<b>To:</b> Lilia Donkova	
<b>From:</b> Philip Skinner Albert Shim	<b>Copy:</b> Chris Ritchie Andrew Hartcher Derek Mullins
<b>Project no.:</b> AUS0195440-1	<b>Date:</b> 28 May 2013
<b>Subject:</b>  <b>DETAILED REVIEW OF CRAWFORD'S PRELIMINARY HAZARD ANALYSIS (PHA)</b>

The preliminary hazard analysis (PHA) for Crawfords Freightlines Pty Ltd, Sandgate Ammonium Nitrate Storage Facility has adequately met the requirements of the Hazardous Industry Planning Advisory Paper (HIPAP) No. 6 *Hazard Analysis*. The methodology adopted for the risk assessment, estimation of consequences and selection of accident likelihood data for hazardous incidents is typical, appropriate and consistent with other similar ammonium nitrate (AN) quantitative risk assessments (QRAs). The Department considers the methodology of the PHA to be acceptable.

Figure 4: Individual Fatality Risk Contours

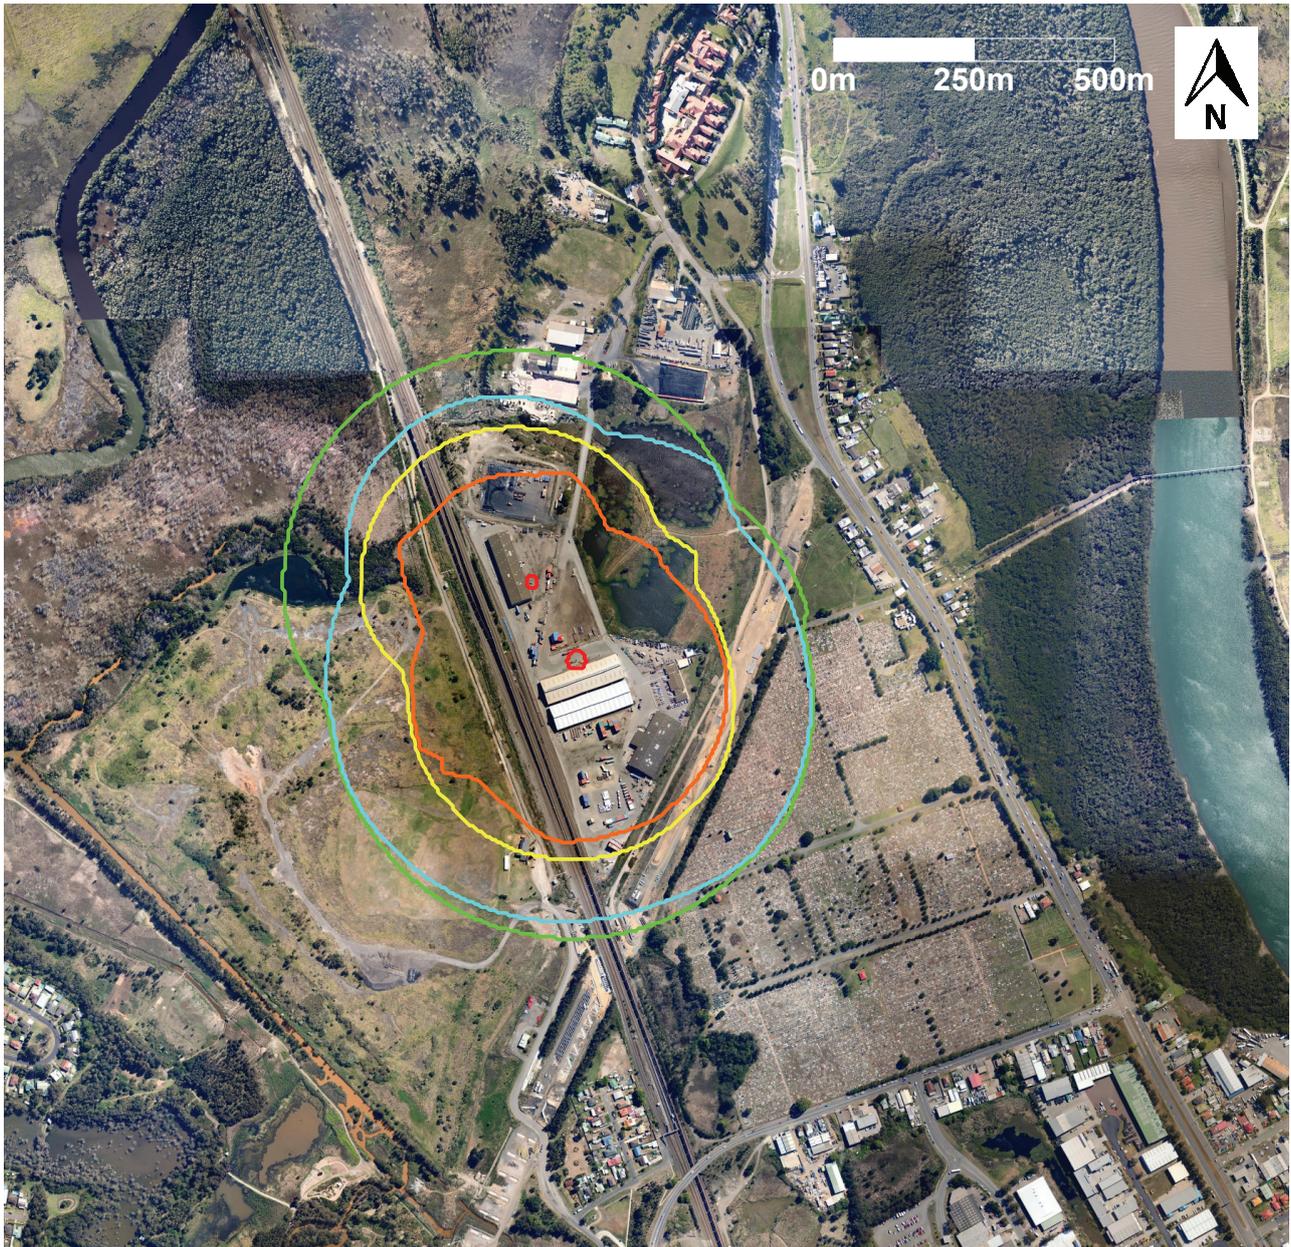
The contour for the active open space criterion (viz. orange line at 10 pmpy) extends approximately 250 m beyond the west boundary. We understand that part of this land is leased to a private entity for the purpose of a Golf Driving Range and as such it should be considered an open space land use. Consequently, the Department requested additional information on the magnitude of the risk and potential presence of people at this area. This is detailed in the next figure.

At the boundary to the area zoned for active open space, the risk level reaches 30 pmpy and reduces to 10 pmpy prior to reaching the clubhouse. The area within the golf driving range where the 10 pmpy criterion is exceeded, is not normally occupied. The area affects two parcels of land, both owned by Newcastle City Council. Crawford's is currently in consultation with the leaseholder of the golf driving range and Newcastle City Council regarding this issue. To ensure that the public access to the area is restricted, an appropriate Condition of Approval is imposed.
